Planning Department

January 3, 2018

**RE: 3147 & 3151 Erratic St. SW Drainage Complaint against
Anderson Heights Unit 7 (N08D006C)**

TITLE: **ANDERSON HEIGHTS (UNIT 7+8) &
GRADING AND DRAINAGE PLAN UNITS**

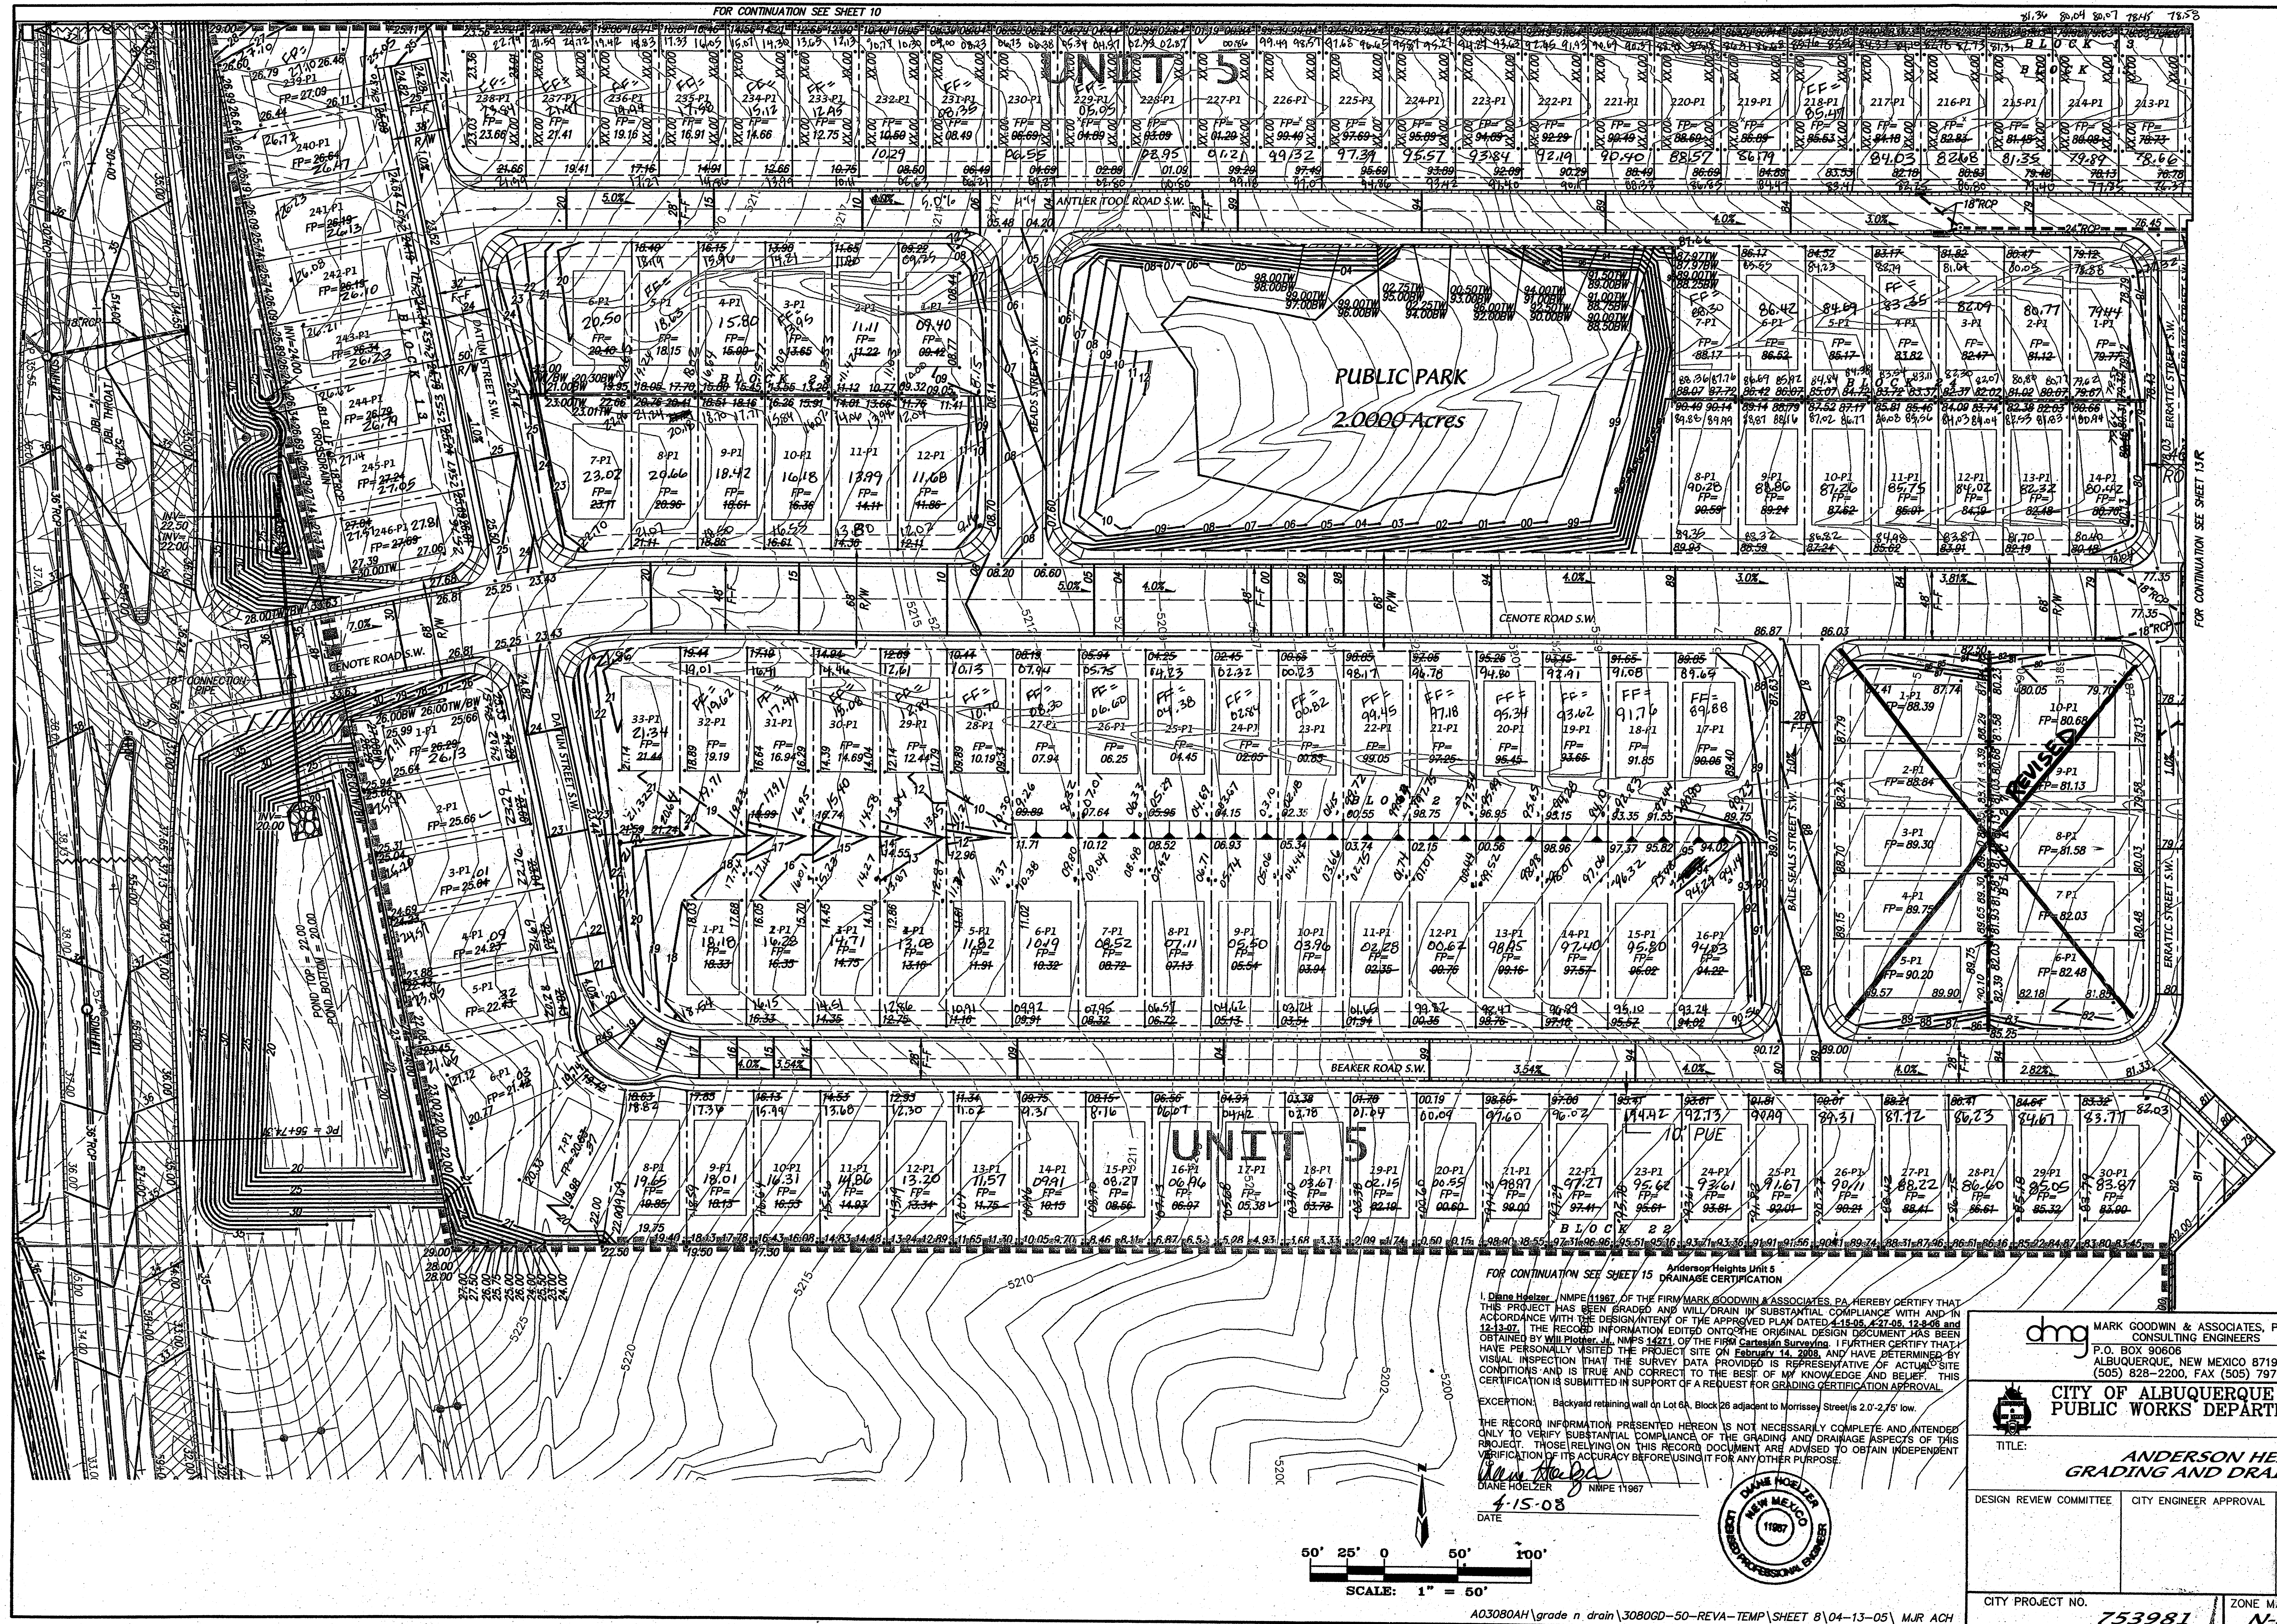
The Grading and Drainage Plan with engineer's stamp dated 12/13/07 showed a diversion of the on Parcel B which the Engineer's Certification dated 4/15/2008 says "has been graded and will drain in substantial compliance with and in accordance with the design intent of the approved plan". However the diversion on Parcel B was not constructed.

The diversion as designed in 2007 included the construction of an 8' high retaining wall on the boundary between these lots and Parcel B. It is unclear whether or not the wall was constructed according to the 2007 plan because it may not be high enough and it may not have been constructed to hold back as much fill as was originally planned.

The grading of the diversion which included the backfill against the Parcel B side of the wall does not appear to have ever been constructed. So anyone placing backfill now will be responsible for proving the adequacy of that wall and will be required to submit structural plans for the wall stamped by an engineer.

A temporary retention pond sized for the excess precipitation from the 100 year storm (0.44" x 28 ac = about 1700 cy) seems to be the simplest and least expensive solution. If a dam could be constructed to hold that much volume without moving more than 500 cy it would not even require a grading permit.
